**Newcastle Coal Infrastructure Group Coal Export Terminal – Section 75W Modification
Application – Approval 06_0009**

We refer to Newcastle Coal Infrastructure Group's (NCIG) application to modify project approval (06_0009) lodged by NCIG on 22 October 2007 (**Modification Application**).

The purpose of this letter is to amend the Modification Application to substitute the **attached** proposed plan of subdivision.

STAGE 1
PROPOSED SUBDIVISION OF LOT 122 DP674948,
LOT 3 DP581473, LOT 6 DP1015754 AND
LOTS 71 AND 74 IN DP1116660

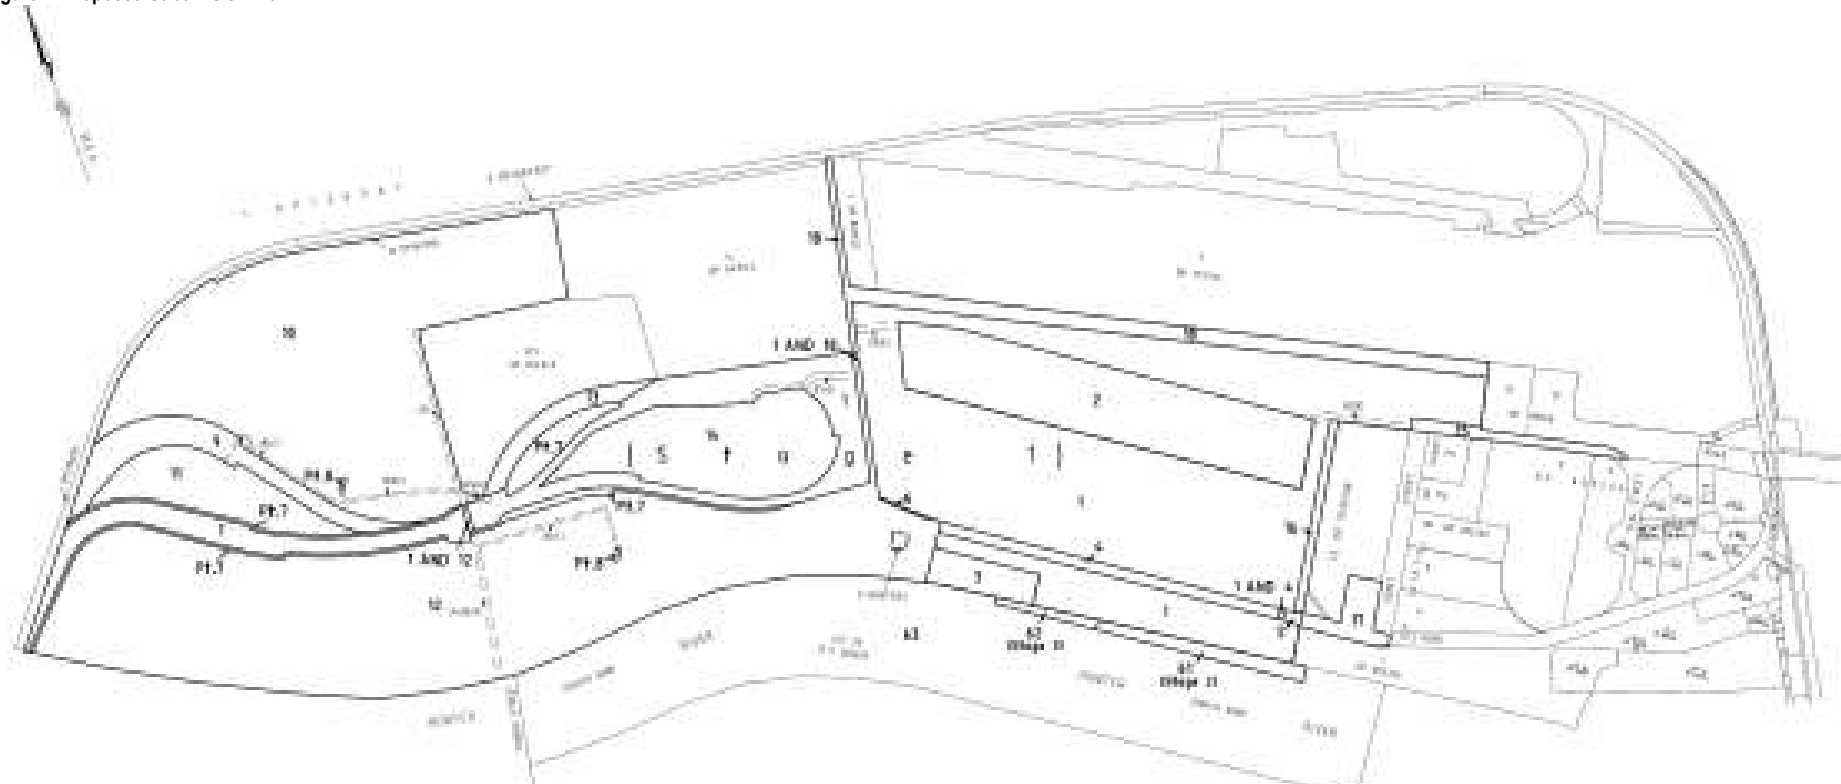
The principal difference between the 2 plans is that the attached plan contemplates 3 stages of subdivision depicted as Stage 1, Stage 2 and Stage 3 on the plan.

- a) Major Projects Application 06_0009;
- b) Environmental Assessment: Newcastle Coal Infrastructure Group Coal Export Terminal, prepared by Resource Strategies Pty Ltd and dated July 2006;
- c) Responses to Submissions, prepared by Newcastle Coal Infrastructure Group and dated December 2006; and
- d) the conditions of this approval; and
- e) Proposed plan of subdivision that forms part of the application to modify Project Approval (06_0009), and identified as Drawing No. VS007 Revision 1.
